KIRKLEES METROPOLITAN COUNCIL INVESTMENT & REGENERATION SERVICE

Reference No: 2026/NM/92299/E

Site Address: Greenside Mills, Saville Road, Skelmanthorpe,
Huddersfield, HD8 9EE

Description: Non material amendment to previous permission
2021/94622 for Reserved Matters application pursuant
to outline permission 2018/60/91787/E for demolition
of existing buildings and structures and erection of
residential development

Tobermore Secura Grand
Retaining Wall Location Plan

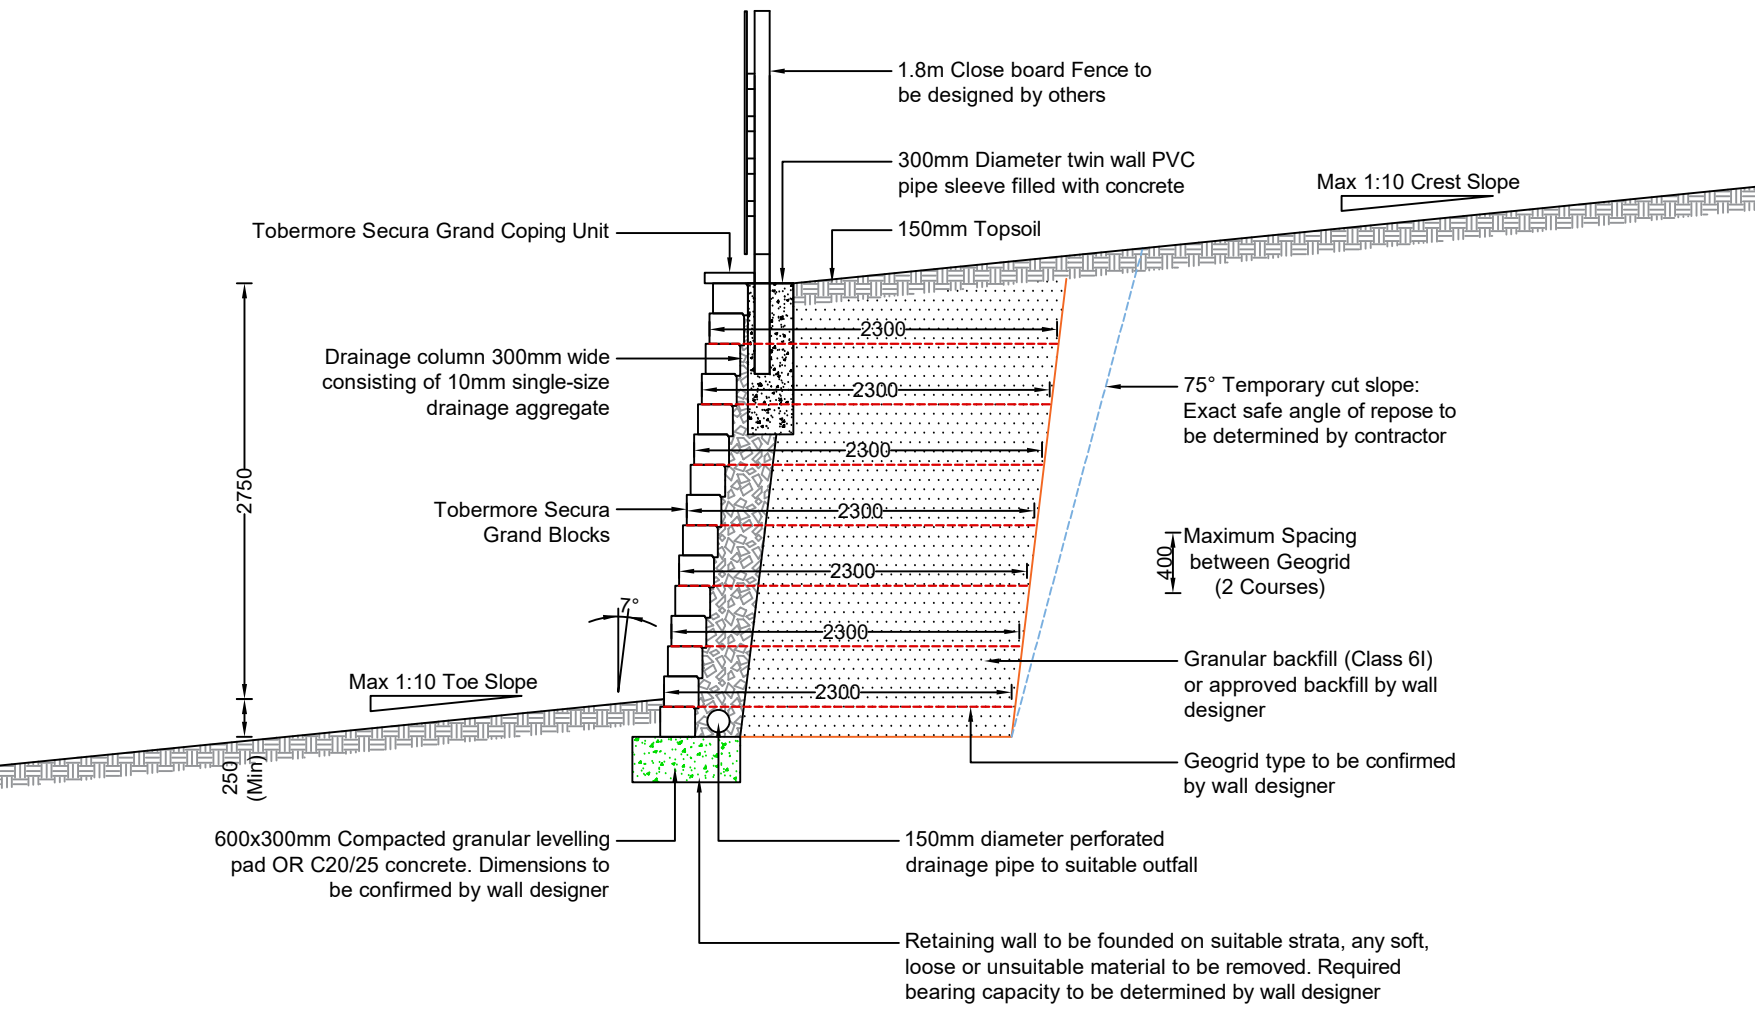
The proposal is to amend the construction of the identified retaining walls from walls faced in Cromwell weathered pitch face artificial stone, to either a 'Tobermore' interlocking concrete construction, in colour 'Bracken' as shown on the Tobermore Secura Grand webpage (and confirmed via email correspondence from the applicant), or to face concrete walls in the tobermore modules. This applies to sixteen of the retaining walls identified on

drawing titled "Tobermore Secura Grant Retaining Wall Location Plan" ref TSE-03083-B, Rev B within the submitted Feasibility Proposal document.

15. The hereby approved dwellings shall be externally faced in 'Cromwell Weathered Pitch Face' artificial stone. In accordance with plan drawing reference 2156.66 Rev A the retaining walls identified by a blue line shall be faced in 'Cromwell Weathered Pitch Face' artificial stone. All other retaining walls shown on plan drawing reference 2156.66 Rev A shall be faced in Tobermore concrete walling: colour 'Bracken' as shown on Tobermore Secura Grand webpage unless otherwise agreed in writing by the Local Planning Authority.
